Geotechnical Engineering Study
Pearsons Ministries Facility Improvements
Green Mountain Falls, Colorado

Yeh Project No.: 219-217

July 22, 2019
Revised November 21, 2019

PCD File No. PPR1933

EXTENDED DETENTION PONDS

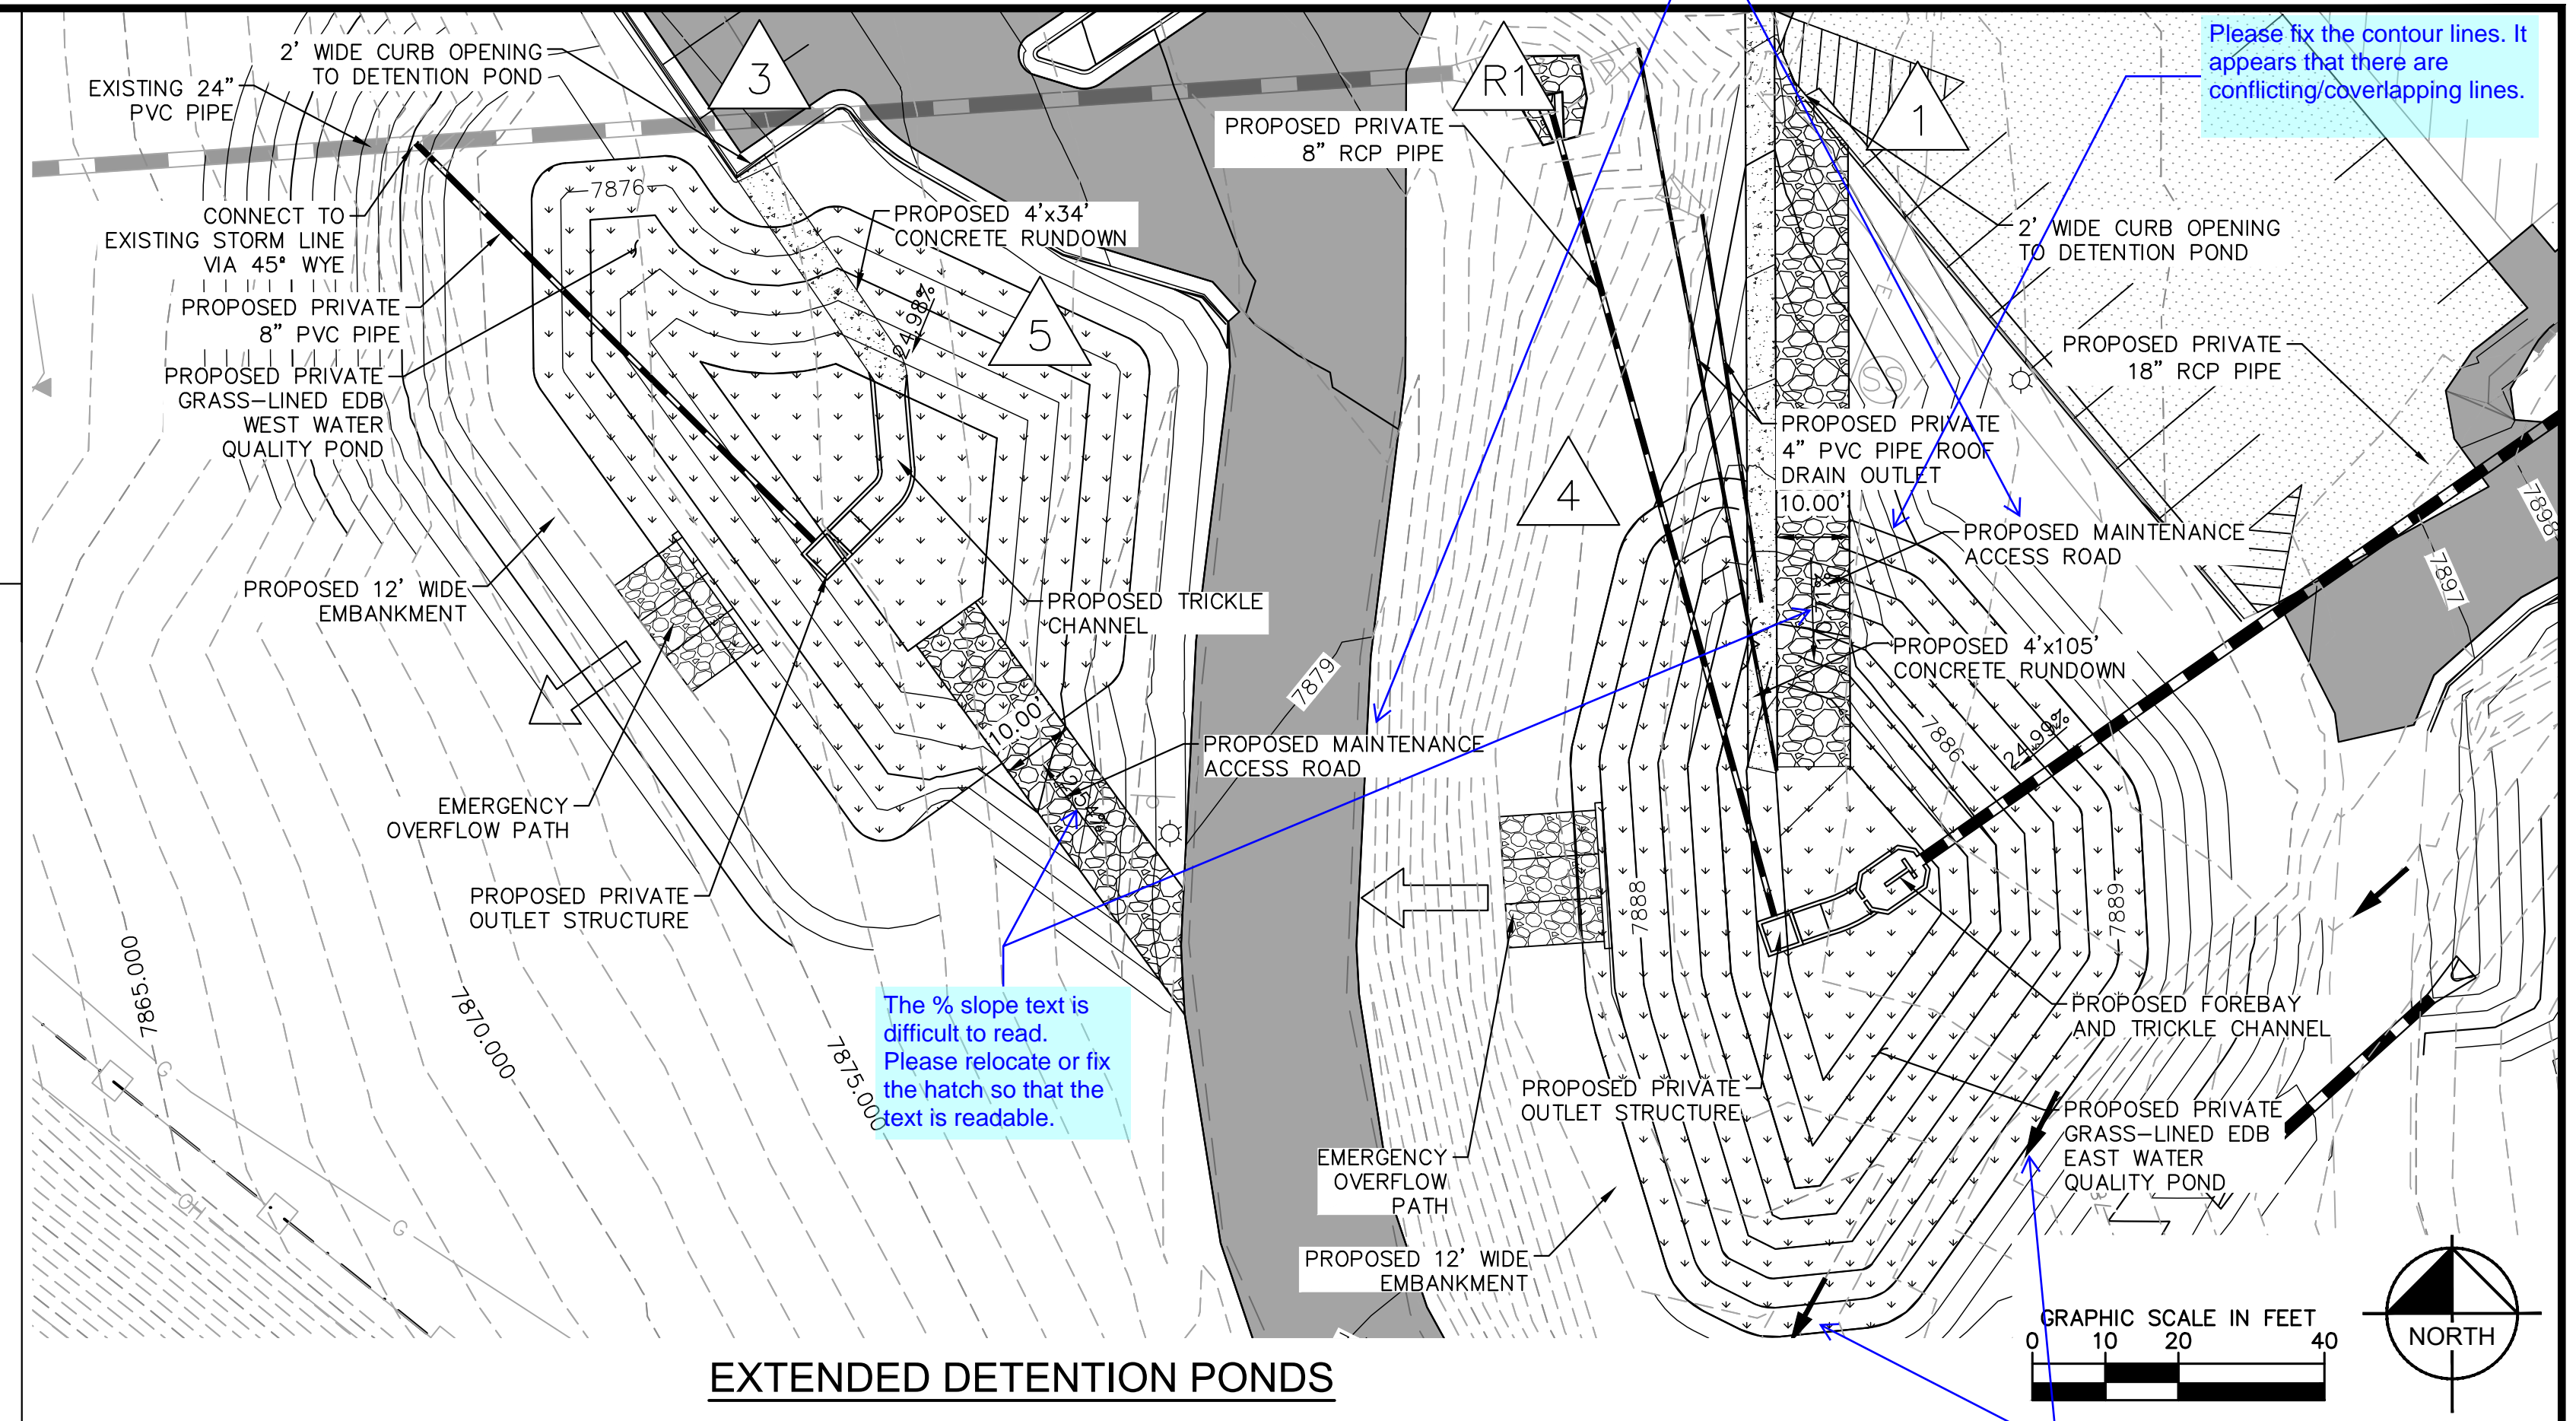
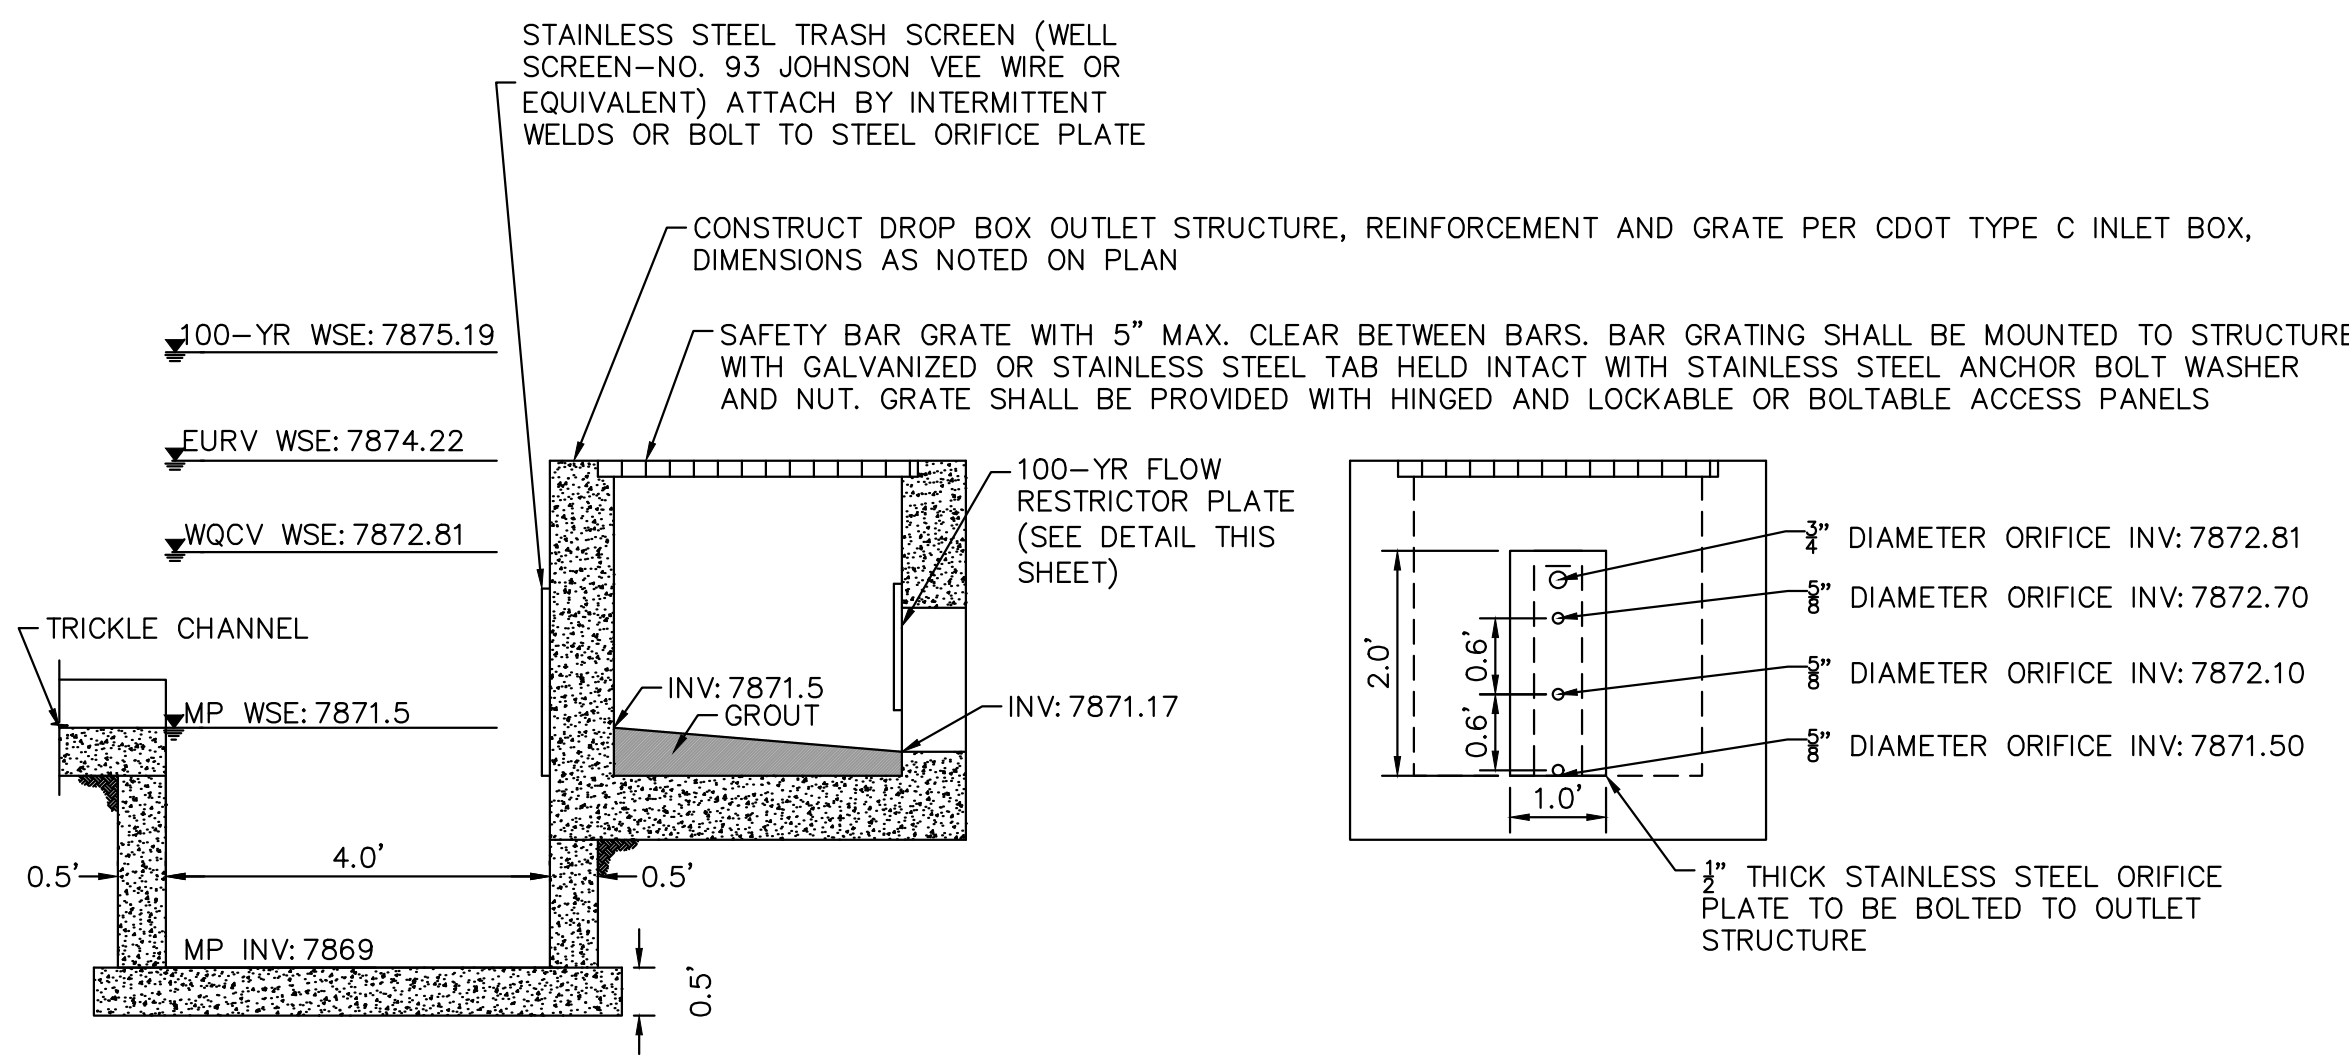
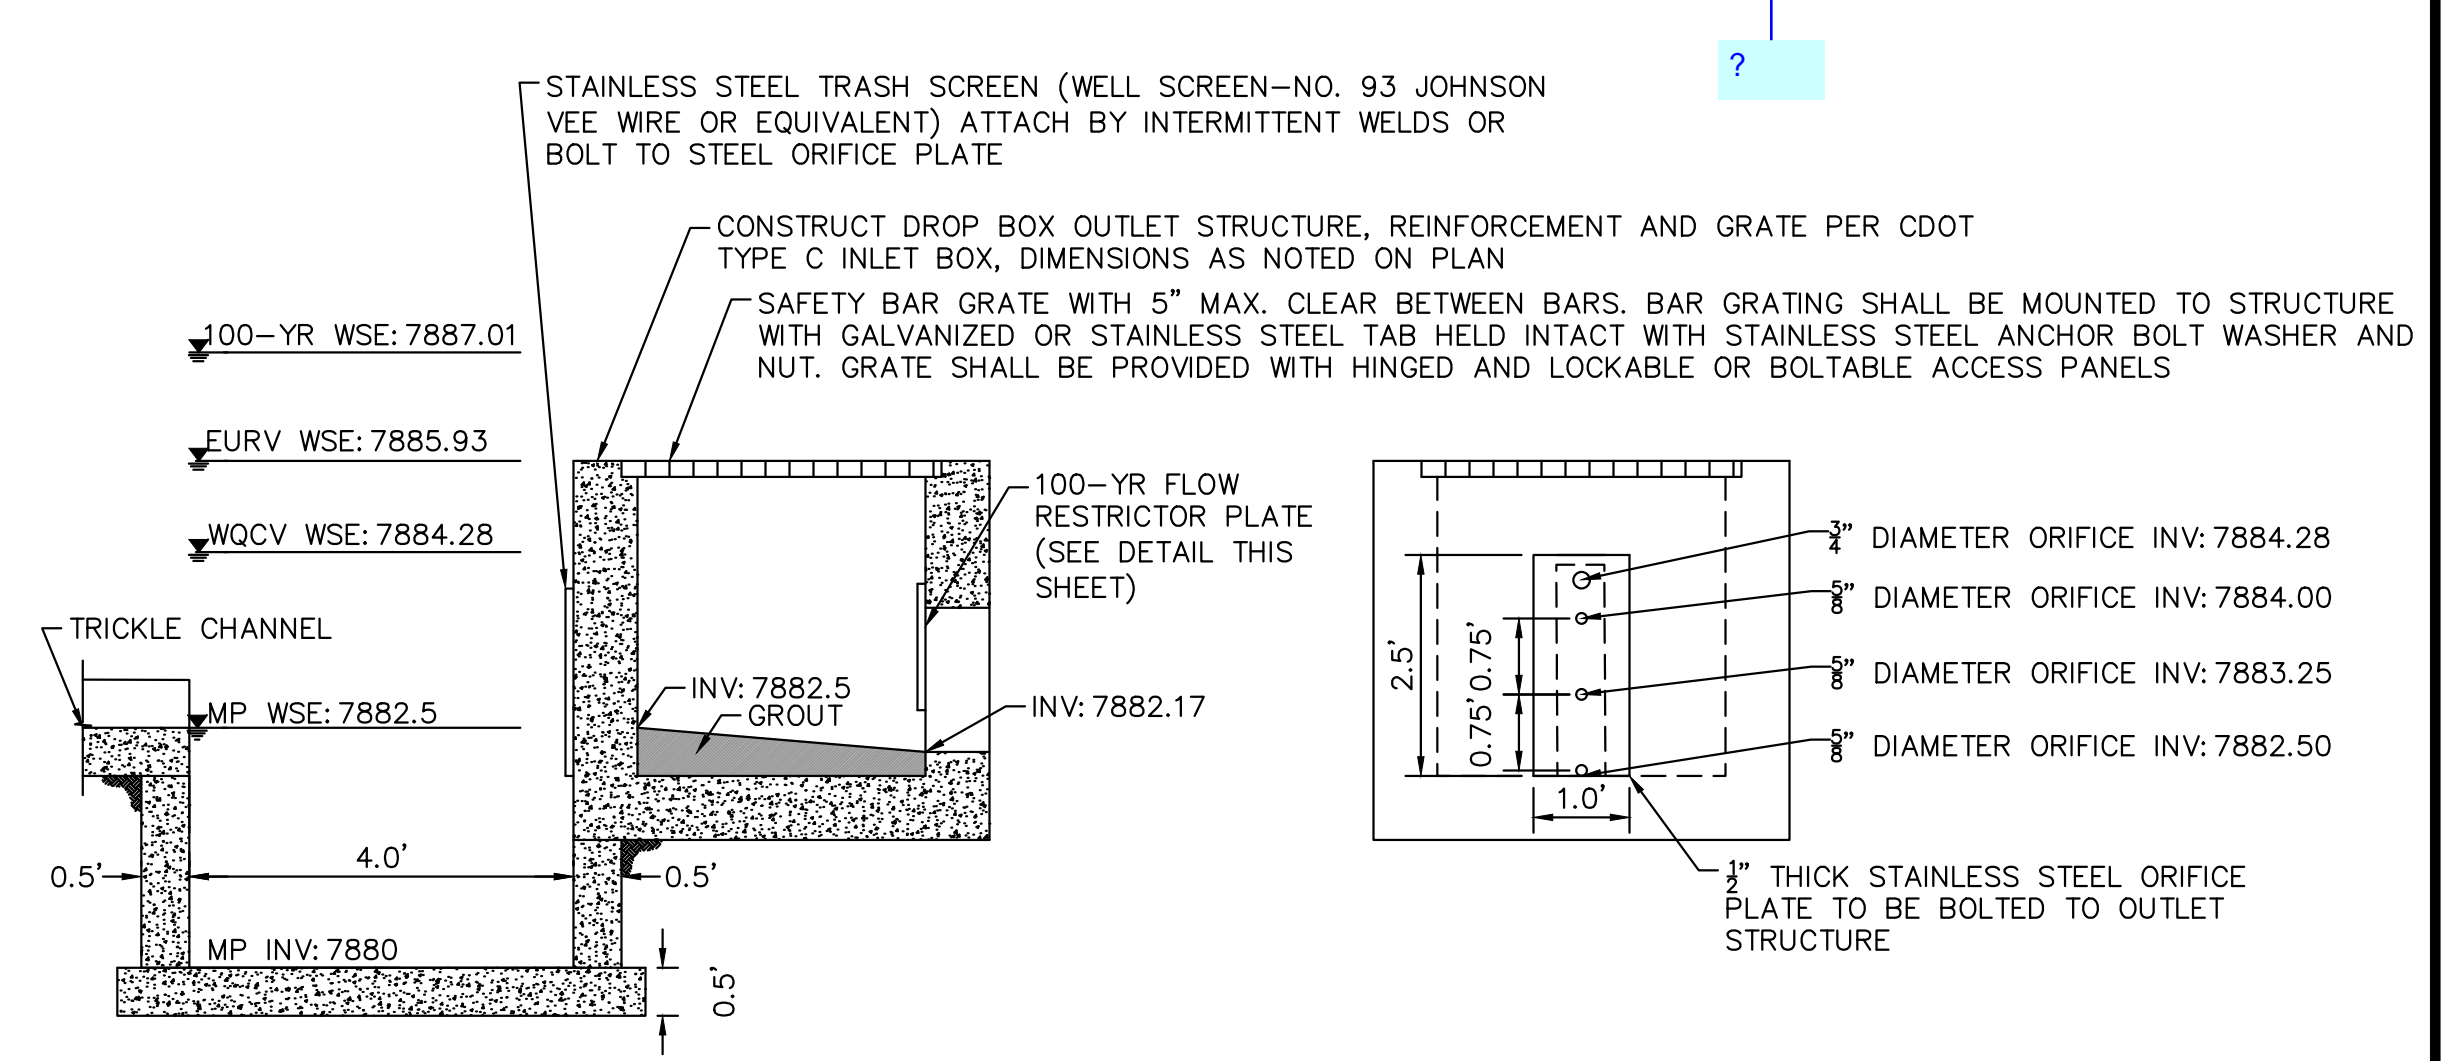
This report does not provide recommendations for the detention facility. Per Chapter 11, section 11.3.3 of the El Paso County Drainage Criteria Manual a Geotechnical report with recommendations for the foundation preparation and embankment construction shall be submitted with the complete design analysis for all permanent detention facilities. Please provide the appropriate recommendations for the detention facilities per DCM Vol. 1 Section 11.3.3.
